OXFORDSHIRE COUNTY COUNCIL'S RESPONSE TO CONSULTATION ON THE FOLLOWING DEVELOPMENT PROPOSAL

Application no: 21/04275/OUT

Proposal: OUTLINE - with all matters reserved except for Access - Mixed Use Development of up to 3,100 dwellings (including extra care); residential and care accommodation(C2); mixed use local centre (comprising commercial, business and service uses, residential uses, C2 uses, local community uses (F2(a) and F2(b)), hot food takeaways, public house, wine bar); employment area (B2, B8, E(g)); learning and non-residential institutions (Class F1) including primary school (plus land to allow extension of existing Gagle Brook primary school); green Infrastructure including formal (including playing fields) and informal open space, allotments, landscape, biodiversity and amenity space; burial ground; play space (including Neaps/Leaps/MUGA); changing facilities; ground mounted photovoltaic arrays; sustainable drainage systems; movement network comprising new highway, cycle and pedestrian routes and access from highway network; car parking; infrastructure (including utilities); engineering works (including ground modelling); demolition

Location: Adj Lords Lane And SE

Appendix C: Development Framework Plan

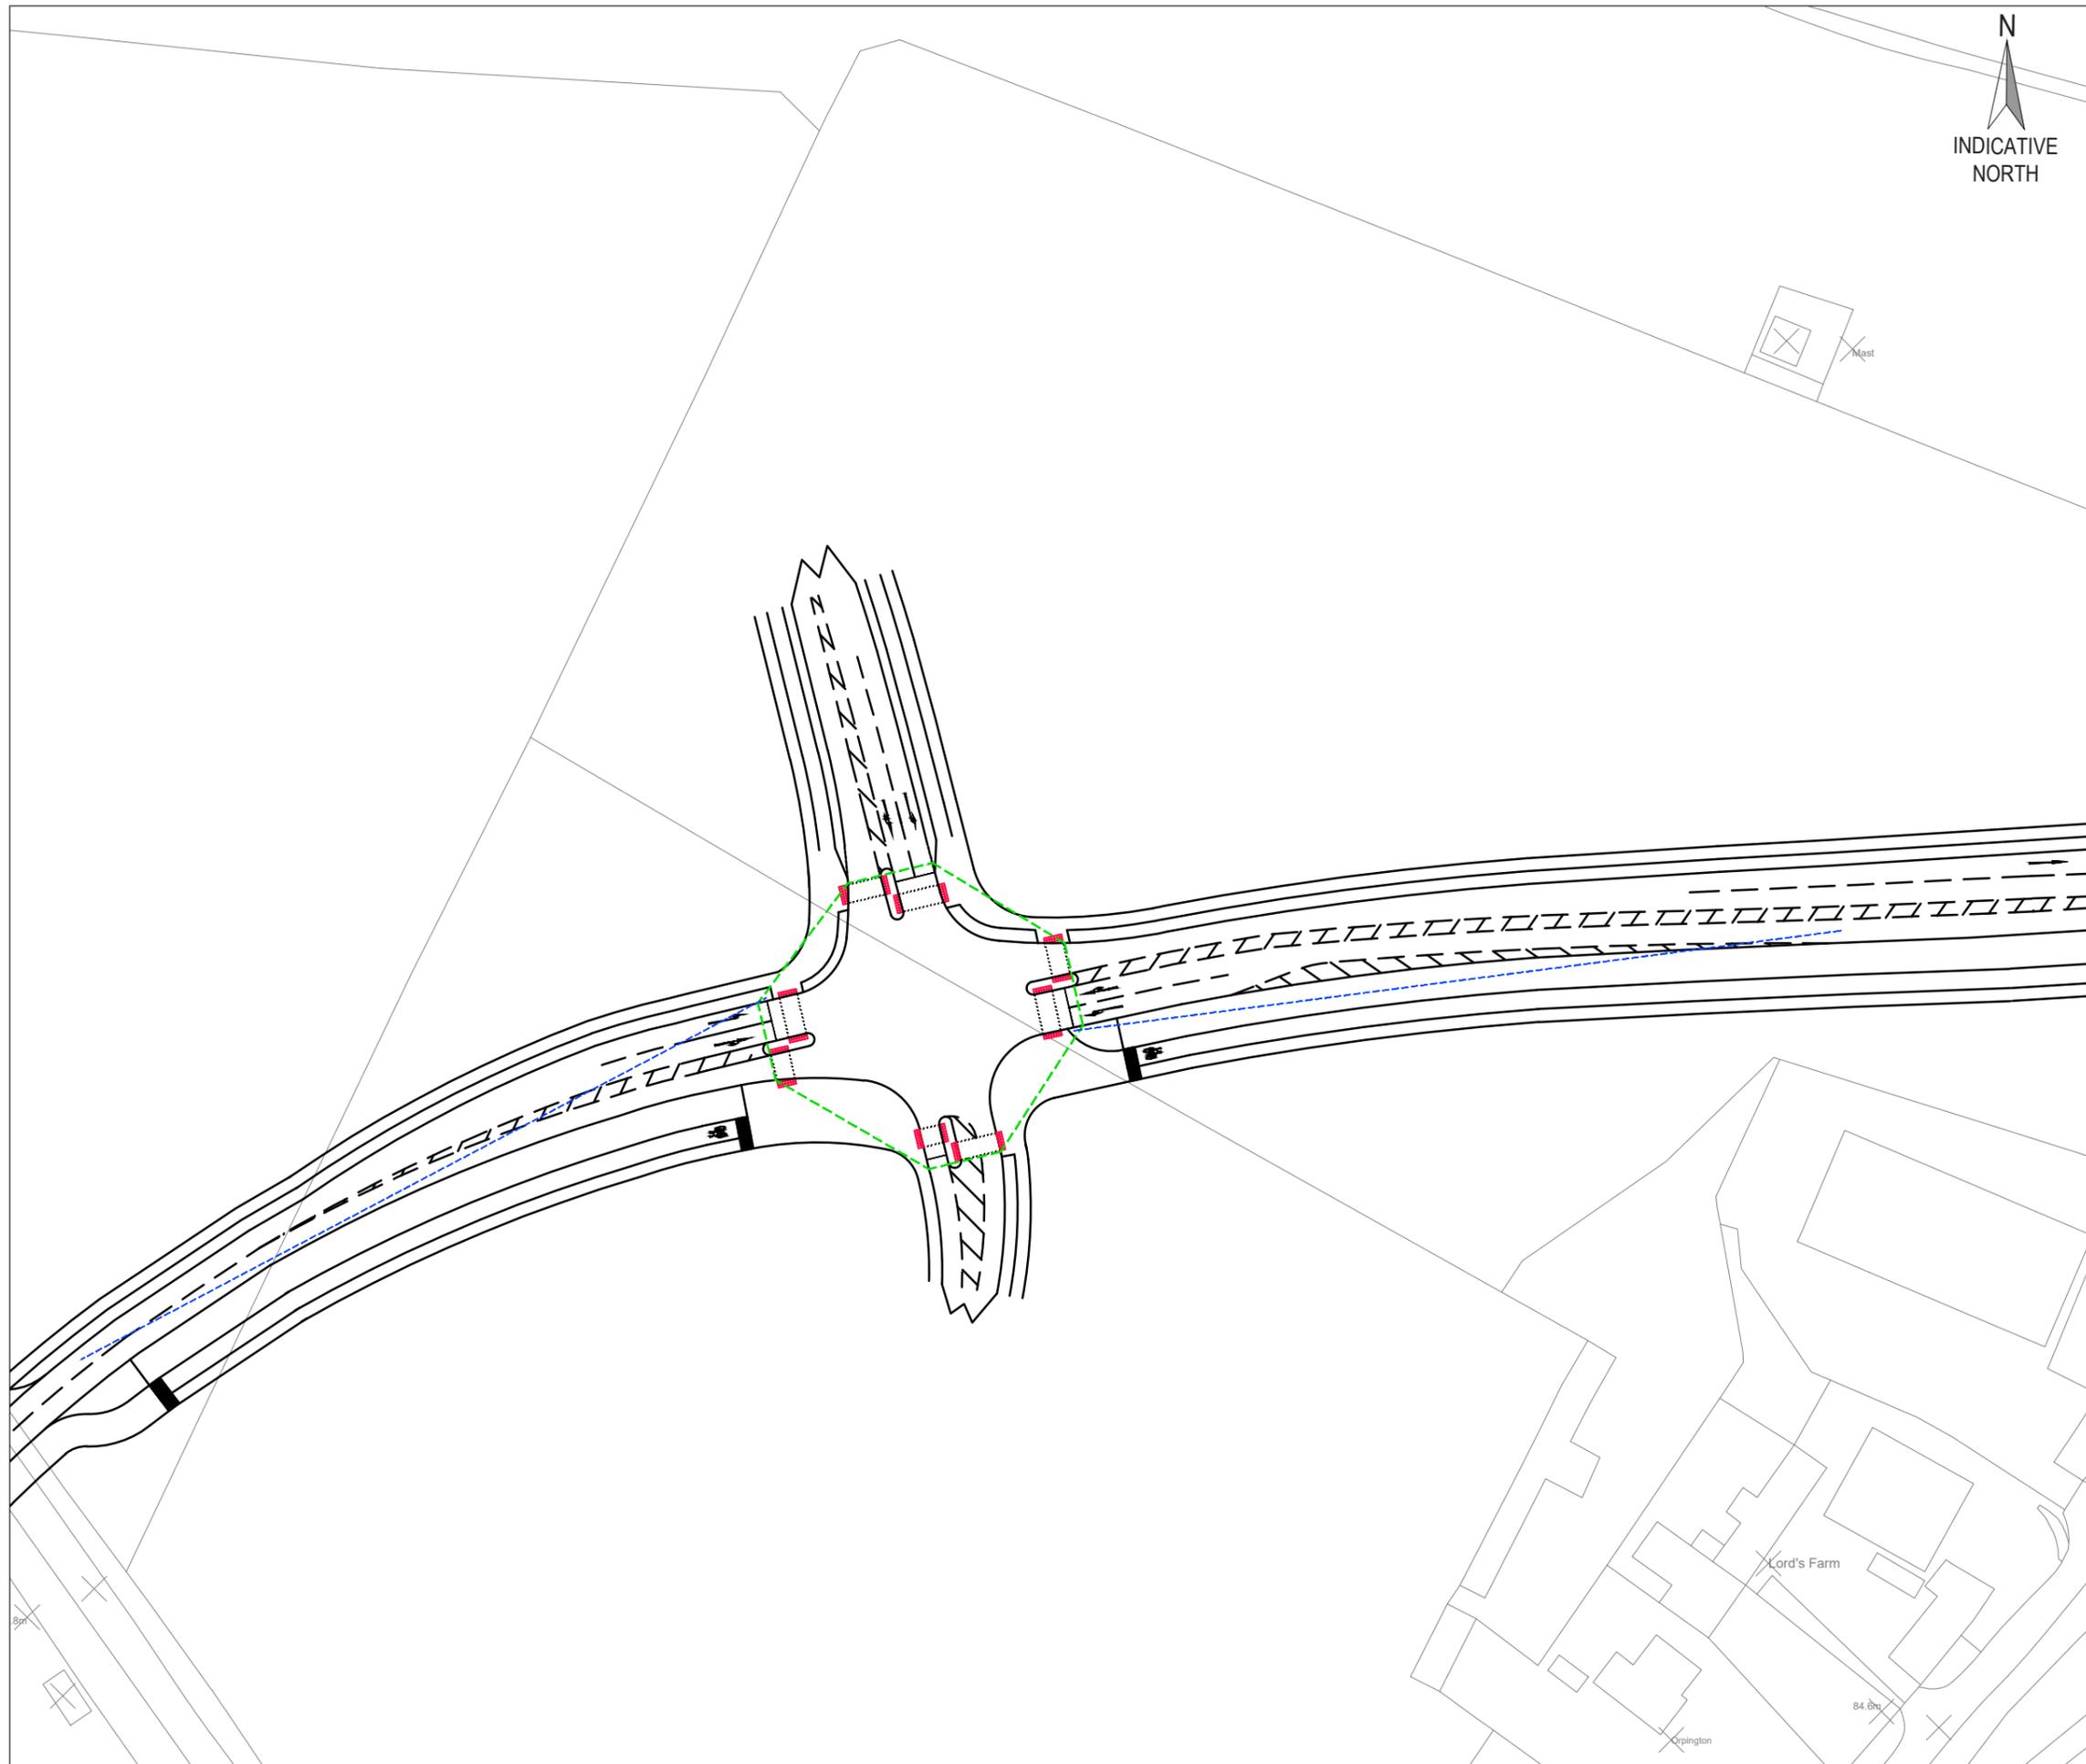
- Appendix C shows the proposed connection point into Cranberry Ave (Elmsbrook). It is understood this connection has now been secured through a legal agreement between landowners. This is to be a bus/active travel connection only and should therefore be designed with a narrowed carriageway. The drawing does not reflect agreed arrangements for the school extension, however. It has been agreed that the car park extension will be accessed from the existing Gagle Brook car park so there is no need for general traffic to use any part of this road. Enforcement camera and signage will need to be provided. As this is close to a school, it will need an off-carriageway cycle facility, which should be designed into the connection. Also, the road connection into the school playing field to the west is not required, as it has been agreed the access will be through the car park.

Appendix D: Drawing 20300_SK_T007_P3

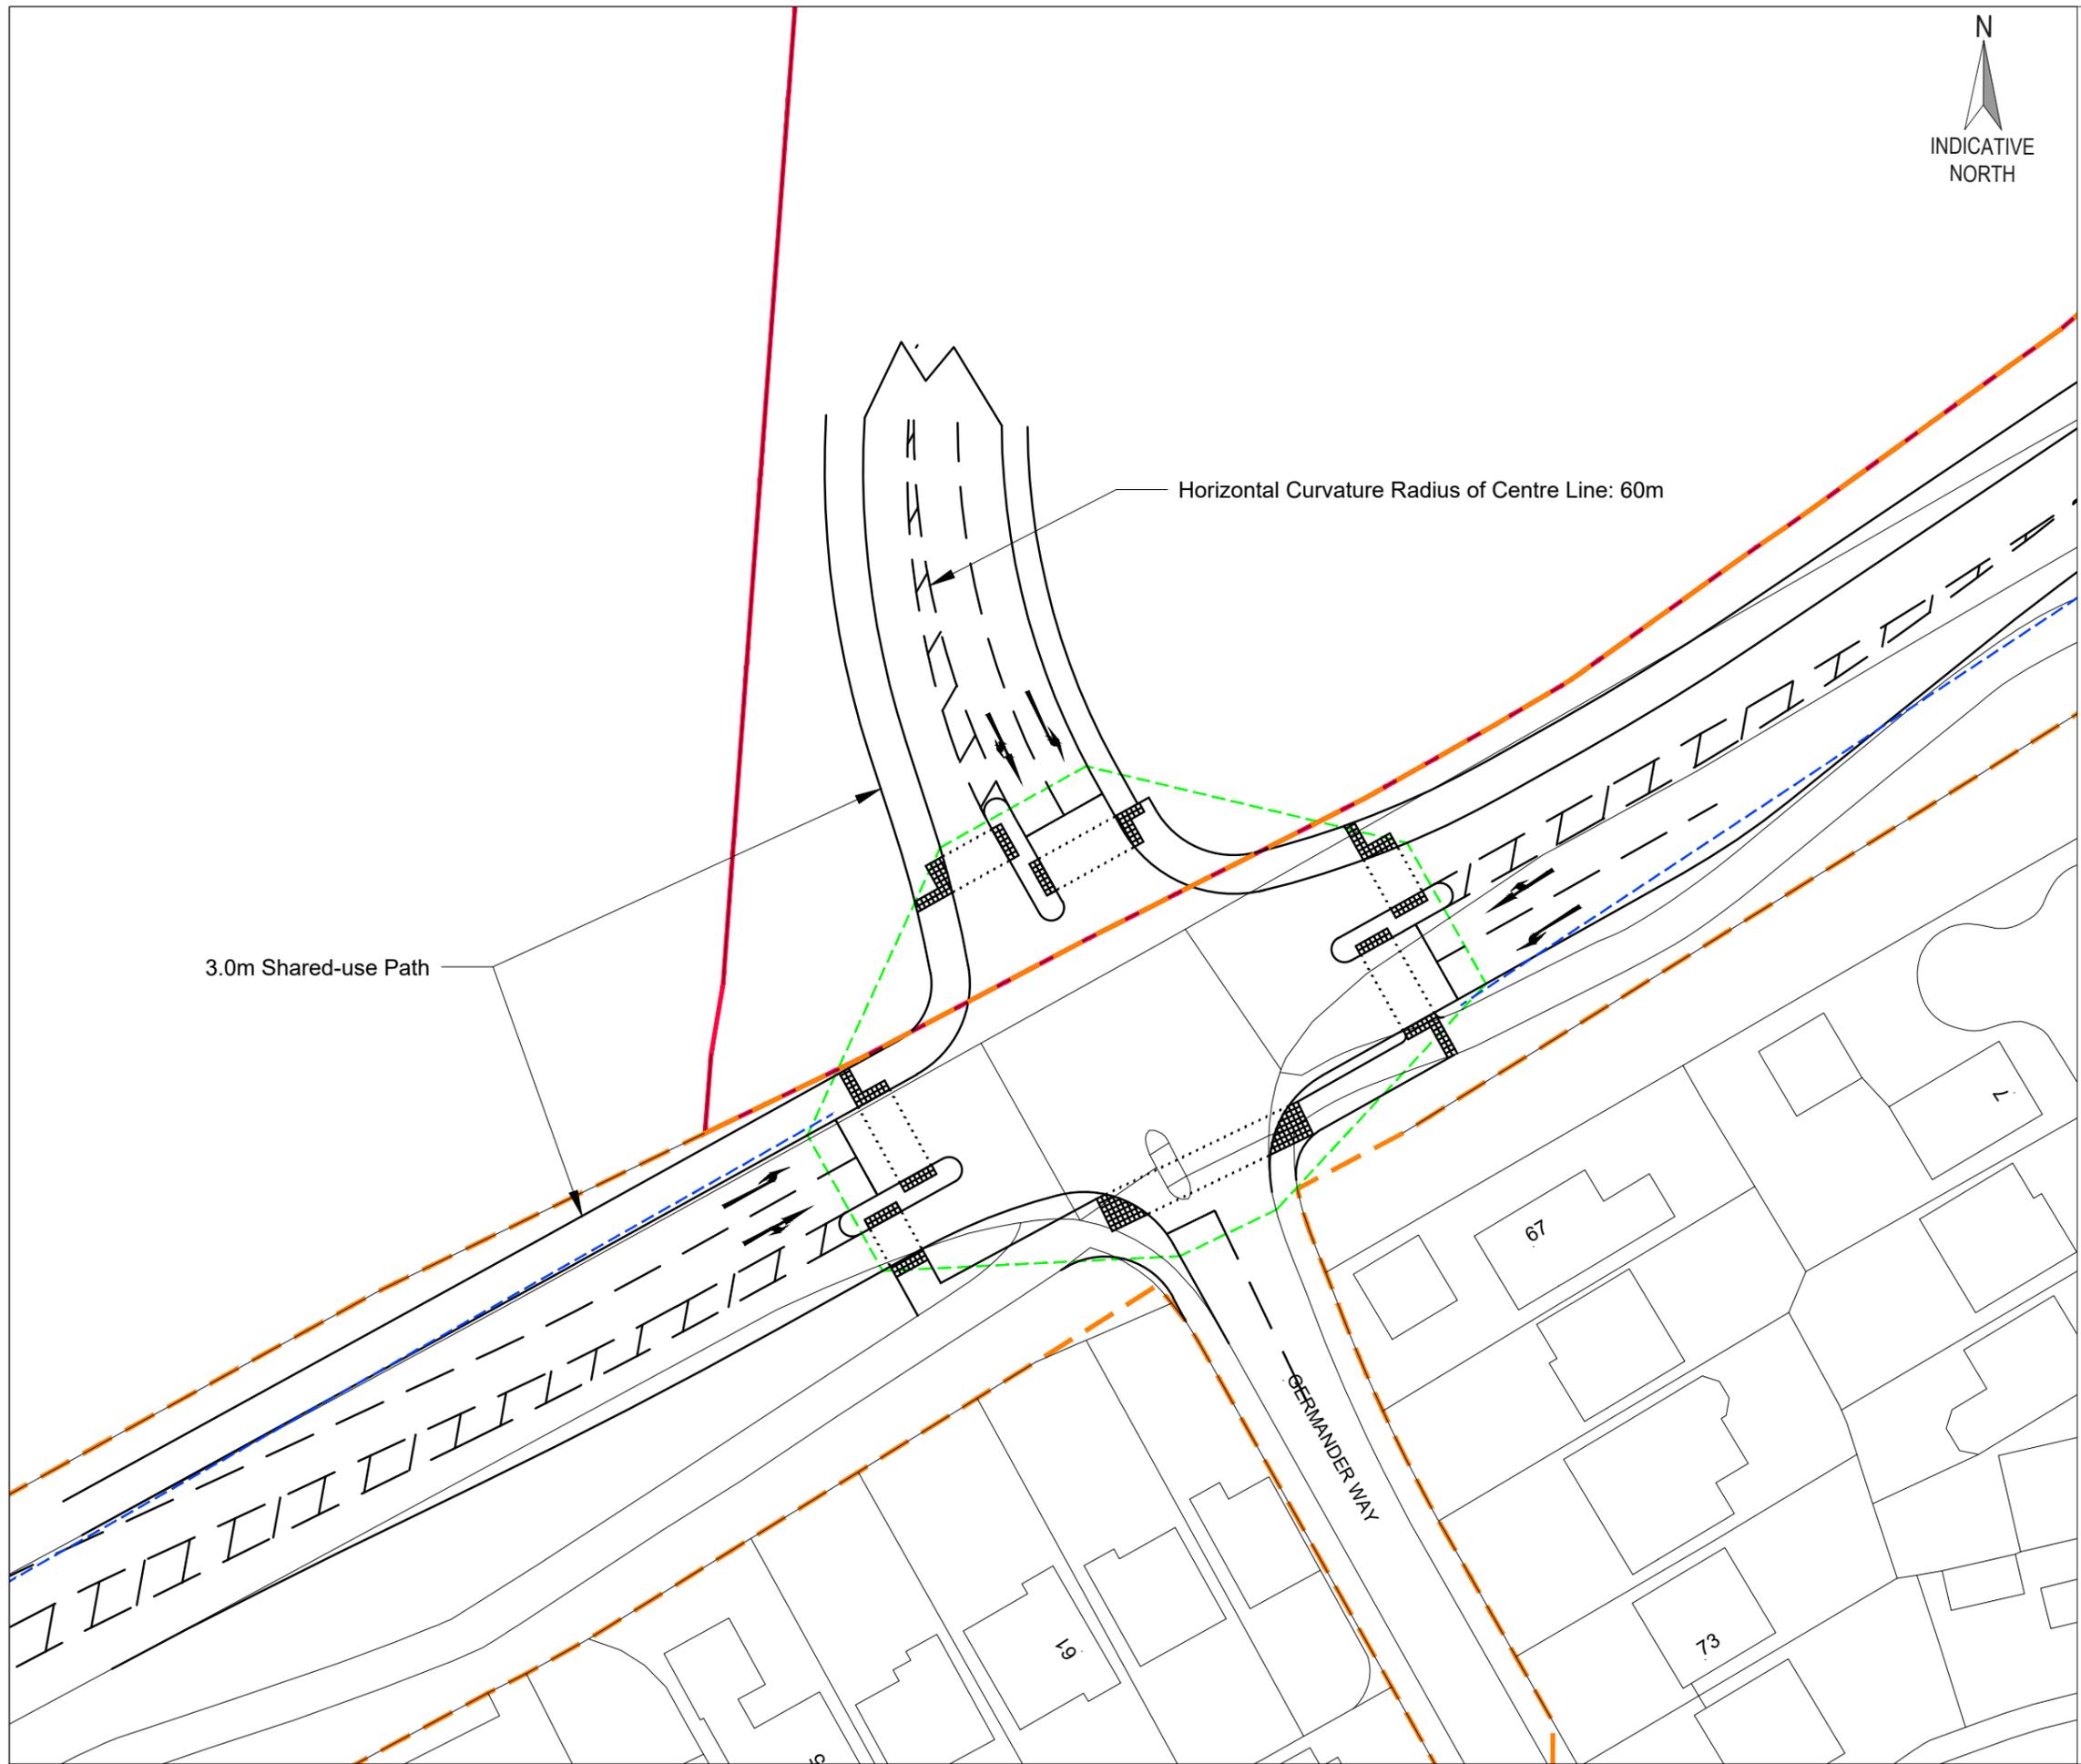
- Appendix D shows internal cycle/ped routes connecting to the ped/cycle route through Bure Park, via a signalised crossing of the A4095 realignment. This will need to be changed in line with the agreed cross section for the A4095 realignment.
